Your reference: DA 165-7-2005 MOD 1  
Our reference: DOC17/354271-05

### **Haerses Road Sand Quarry - DA 165-7-2005 MOD 1 – Applicant's Response to Submissions**

28 July 2017

**DAVID GATHERCOLE**  
Unit Head Sydney Industry  
**ENVIRONMENT PROTECTION AUTHORITY**

Figure 8: Location of noise receivers

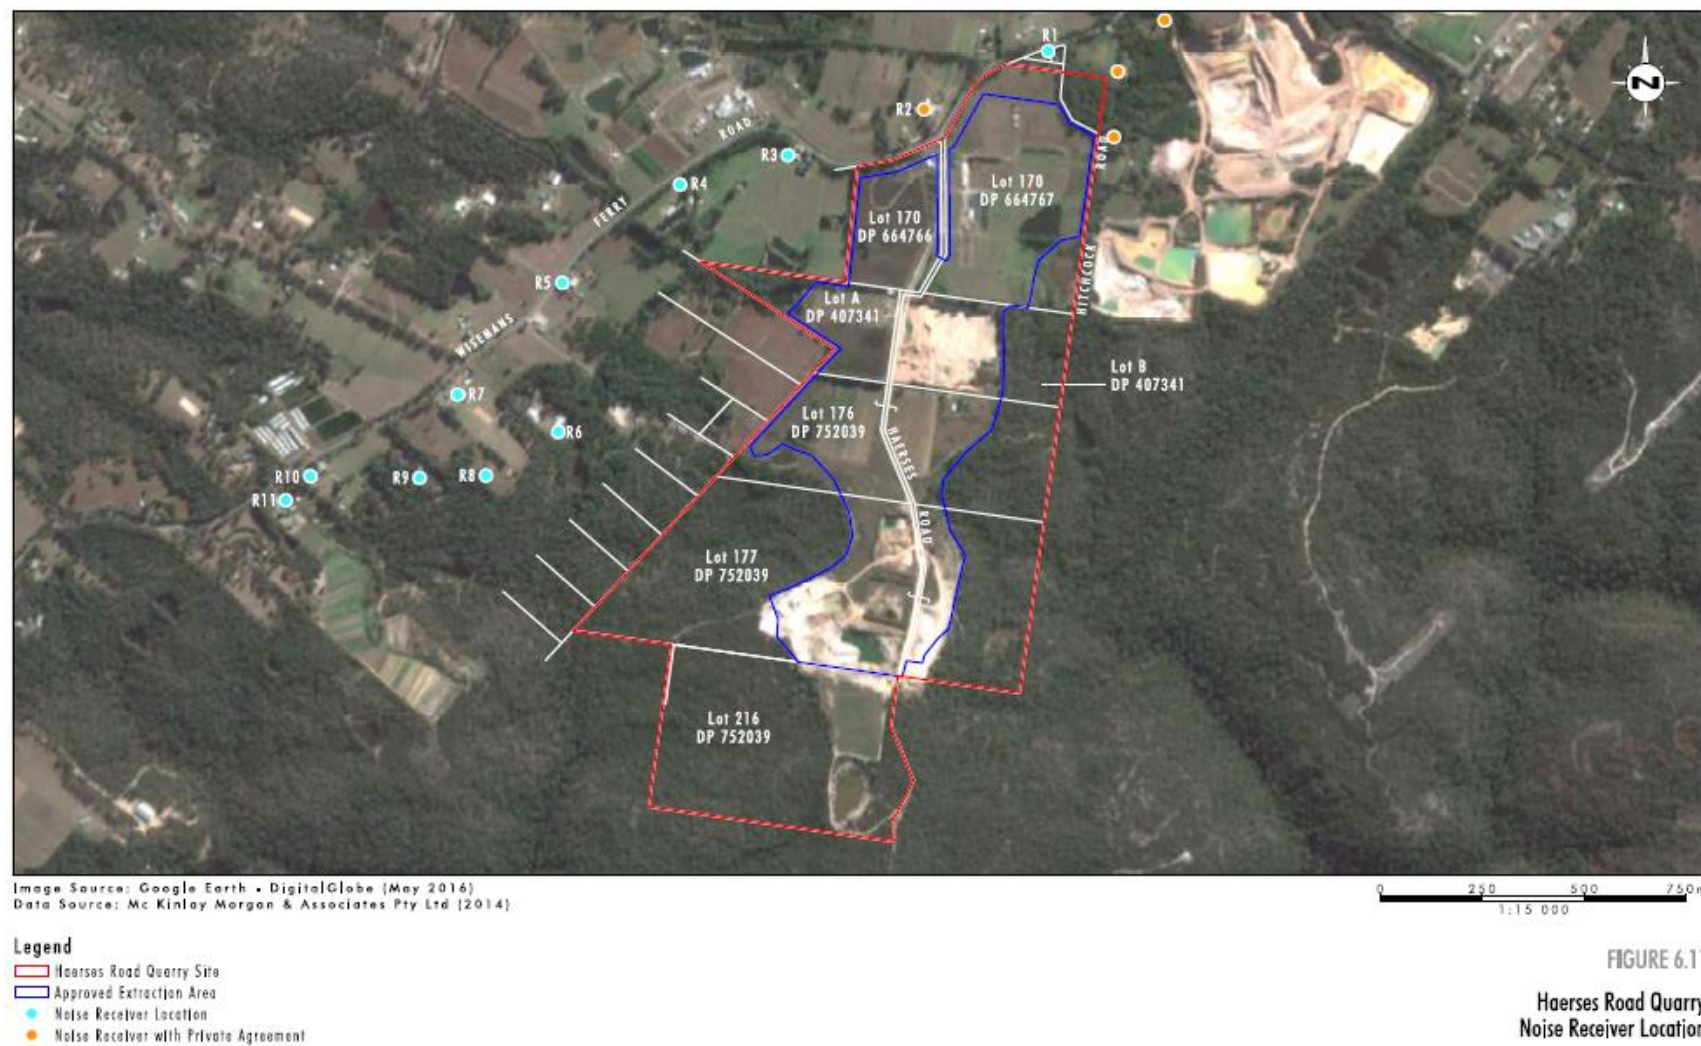
The EPA understands that DPE's preference is to amend the existing noise limits to reflect the noise predictions in the EA (except for bund construction).

The EPA therefore has provided revised noise conditions and limits in **Attachment A** which align with the EA for three additional receivers. The existing noise conditions and limits have been retained for other receivers which aligns with current EPL limits to account for noise emissions from potential extractive activities occurring in the remaining cells of the premises. This is considered to be a clearer approach than setting varying conditions depending on which cell(s) extractive activities are occurring in at any given time.

**L6.1** Except for Cell 4 noise mitigation bund construction, noise generated at the premises must not exceed the noise limits specified in the Table below.

Location	NOISE LIMITS dB(A)		
	Day L <sub>Aeq</sub> (15 minute)	Morning Shoulder L <sub>Aeq</sub> (15 minute)	Morning Shoulder L <sub>A1</sub> (1 minute)
Lot 10 DP 835992, Lot 2 DP 230742	37	37	45
Lot 1 DP 230742	38	38	45
Lot 13 DP 38294	37	37	45

<i>Lot 14 DP 38294</i>	36	36	45
<i>Lot 15 DP 38294</i>	36	36	45
<i>Any other residential receiver not subject to a negotiated agreement</i>	35	35	45

Construction of the Cell 4 noise mitigation bund is to occur only during standard construction hours, as defined in the *Interim Construction Noise Guideline*. Construction should be completed as soon as practicable and within six months of construction commencement.

Figure 9: Location of air quality receivers

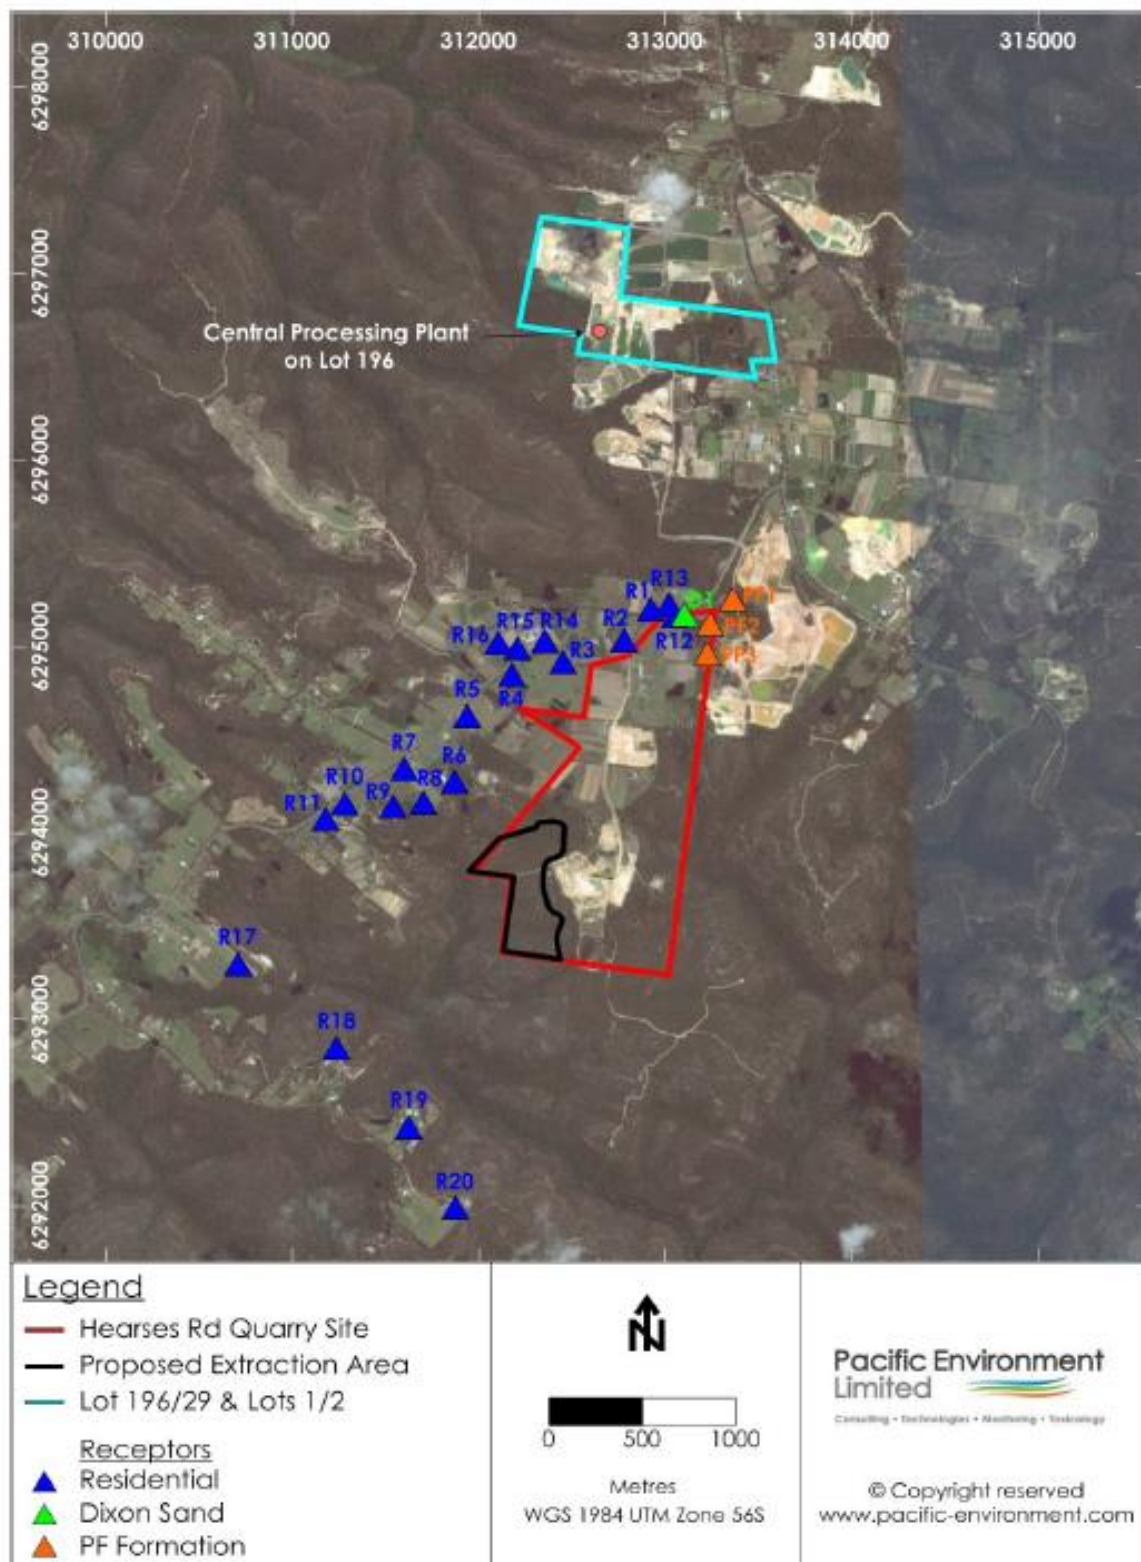
The EPA considers that the RTS addressed most of the issues identified in its November 2016 review of the applicant's environmental assessment (EA). However one aspect requires resolution: the predicted additional exceedance of 24 hour PM10 at receptor R6. In accordance with Section 5.1.3 of the Approved Methods, the proponent must ensure that no additional exceedances will occur as a result of the proposed activity.

However, dispersion modelling in the AQIA predicts a 24 hour average PM10 concentration of approximately 58 µg/m<sup>3</sup> at R6 in October 2015. This exceeds the EPA's impact assessment criterion of 50 µg/m<sup>3</sup>. Figure 13 of the RTS Report indicates that project related activities contributed approximately 26.5 µg/m<sup>3</sup>, with background concentration contributing approximately 31 µg/m<sup>3</sup>. In this circumstance, Condition M2.4 would not have been implemented, and hence would not have prevented the exceedance. Further, R6 is located north-west of the site, and therefore a wind direction of approximately 120°-140° would be required to cause impacts at R6. Since Condition M2.4 applies to winds with direction between 180° and 240°, it would not have been effective in preventing exceedances, regardless of background concentration.

According to the RTS Report, other controls will be implemented at the site that have not been modelled. In order to demonstrate that these controls will be effective in preventing exceedances, the AQIA should be revised to incorporate the controls into the modelling.

**Recommendation:** In accordance with Section 11.2.3 of the *Approved Methods for the Modelling and Assessment of Air Pollutants in New South Wales*, since the AQIA predicts additional exceedances in ground level PM10 concentrations, the proponent must revise the AQIA to demonstrate that additional control measures will be effective in preventing exceedances.
